From: Hannah Kersley
Sent: 17 April 2025 13:35
To: Planning.Responses
Subject: FW: AL/13/25/DOC - R/) Karenza, Hook Lane, Aldingbourne.
Attachments: DB-01P2.pdf; Elevations Plot 2.pdf; Roof Plan Plot 2.pdf; AL-13-25-DOC.docx

From: Hannah Kersley <Hannah.Kersley@arun.gov.uk>
Sent: 15 April 2025 09:14
To: Chris Moore <[REDACTED]>
Subject: RE: AL/13/25/DOC - R/) Karenza, Hook Lane, Aldingbourne.

I have reviewed the documents submitted for Condition 9, and note the documents refer to the use of ASHPs as low and zero carbon, which contribute to 10% energy *saving*. Unfortunately I'm afraid we are unable to accept ASHPs as a source of decentralised / renewable energy, to meet the requirements of Condition 9. This is because the policy is asking for energy generation (supply) from a decentralised and renewable / low carbon energy *source*, and not just a carbon *saving* equivalent. Air Source Heat Pumps do not produce electricity themselves – rather they reduce the electricity required to input into them and as a result reduce the reliance on fossil fuel resources (therefore there is a calculation of saving that can be shown in relation to carbon). Therefore, whilst ASHPs are considered

PROPOSED ELEVATIONS
(PLOT 2)

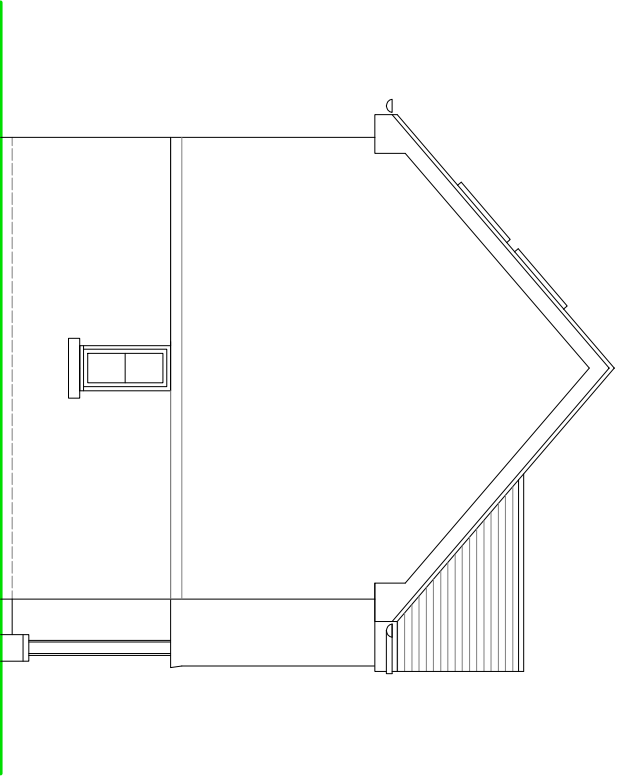
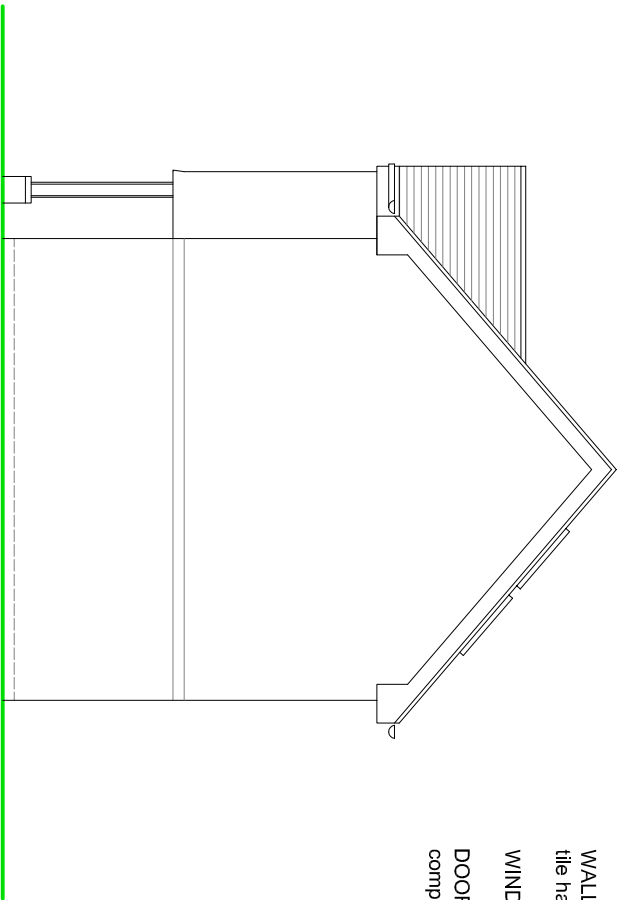
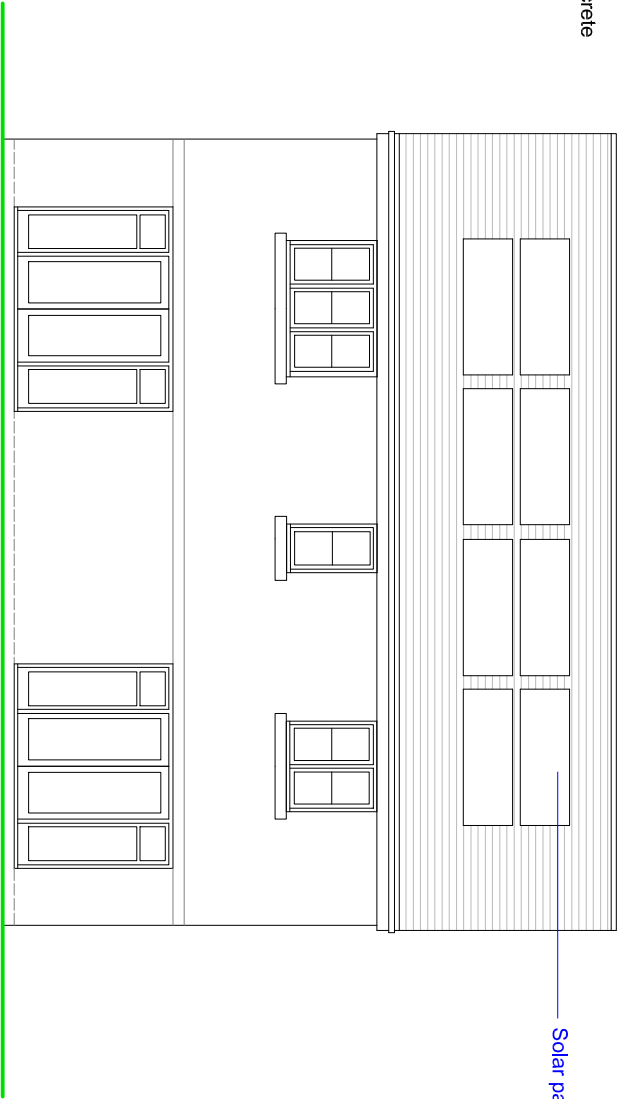
We do therefore require the use of Solar / PV panels (and subsequent details to be submitted for approval), as outlined in the covering letter, in order to meet the requirements of the condition. In order to approve the condition, we will need to see technical specification details of the model / manufacturer of the panel, the number of panels to be used within the development, their location on a plan, and calculations to demonstrate that the panels will contribute a minimum of 10% energy supply for use within the development.

In response to the comments raised, I attach a copy of revised thermal calculations which include the provision of solar panels to Plot 2 to give 2.7 kW of power which would equate to the 10% renewable energy you seek.
